From: christopher.jones@arundel.gov.uk
Sent: 10 February 2020 12:27
To: Sian Eggington
Subject: Jones Projects - 34 pier road amendment to elevation
Attachments: We sent you safe versions of your files; Planning drawings elevations.pdf

Elevations Proposed

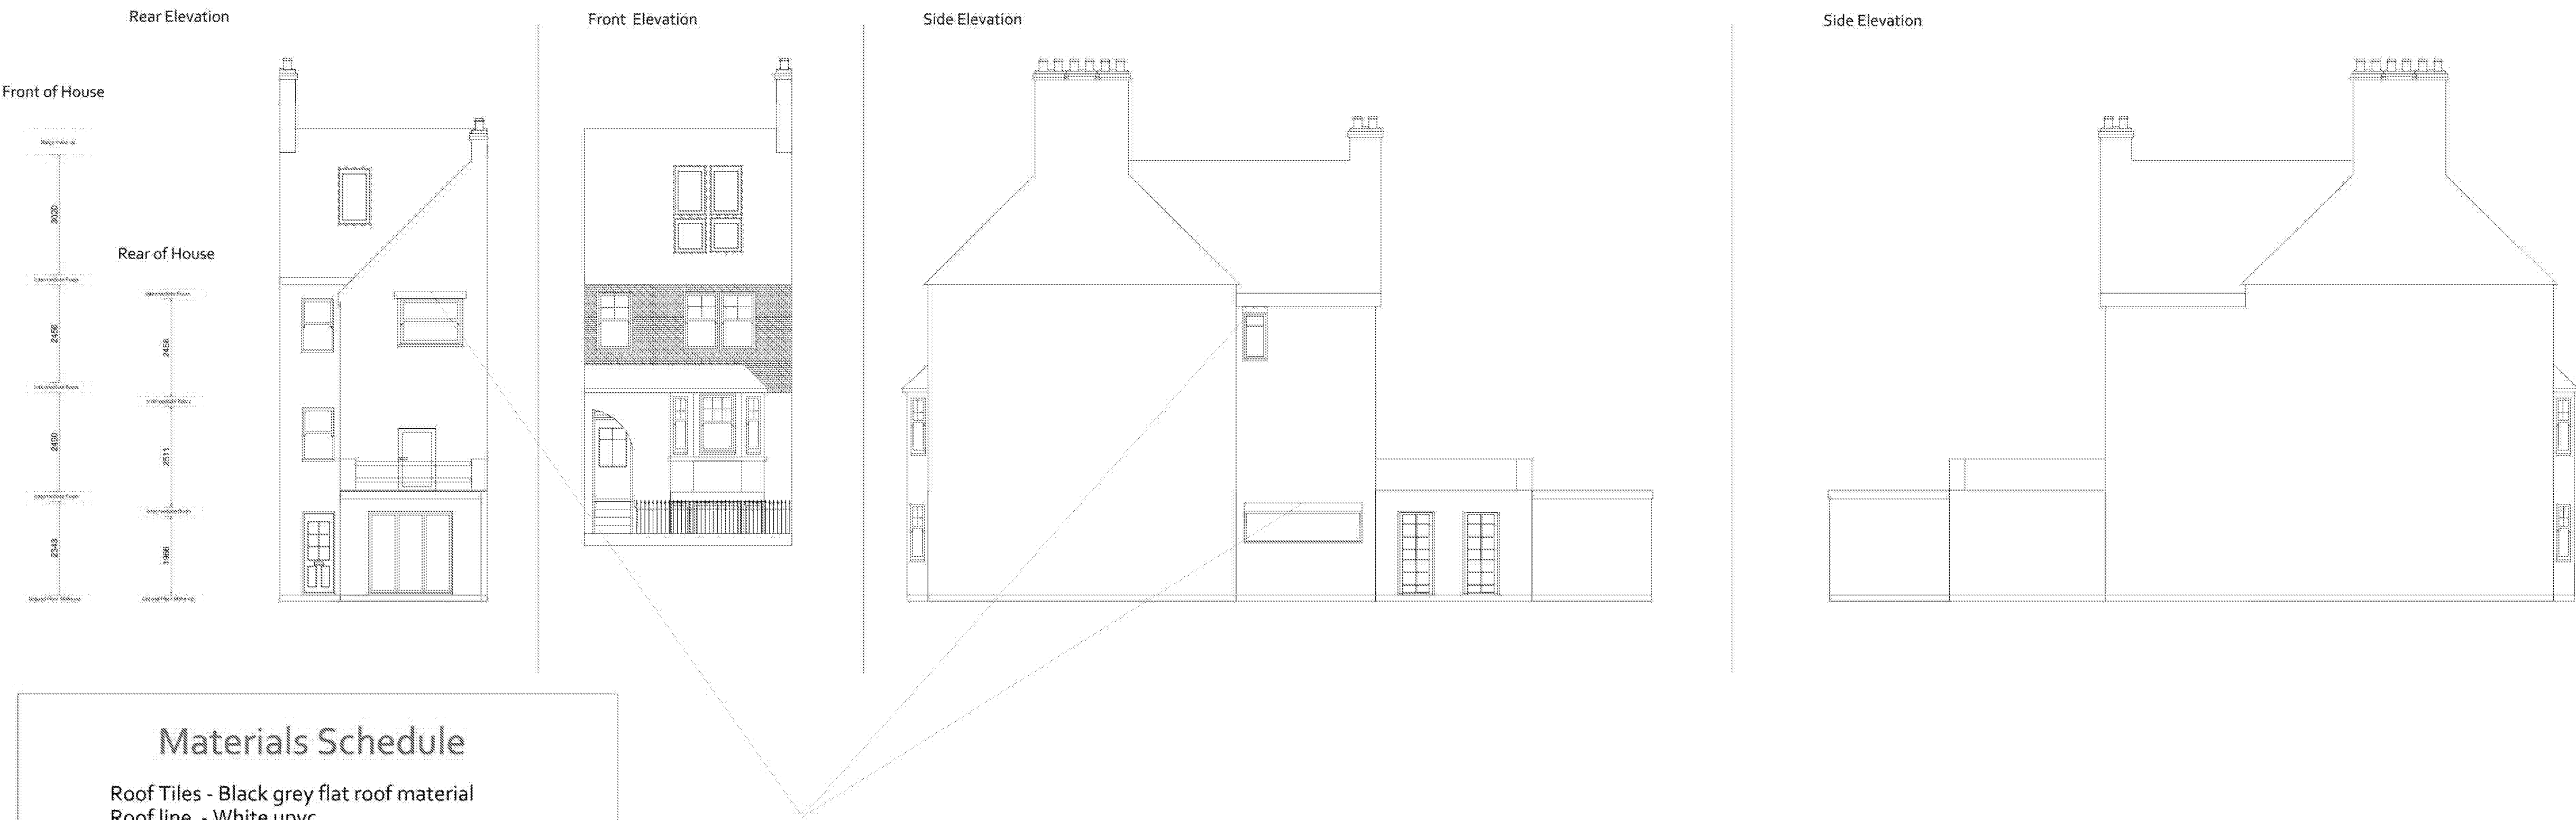
I have noticed a glitch on the elevation and placed a window on the side elevation this is missing from the original drawing , please see attached
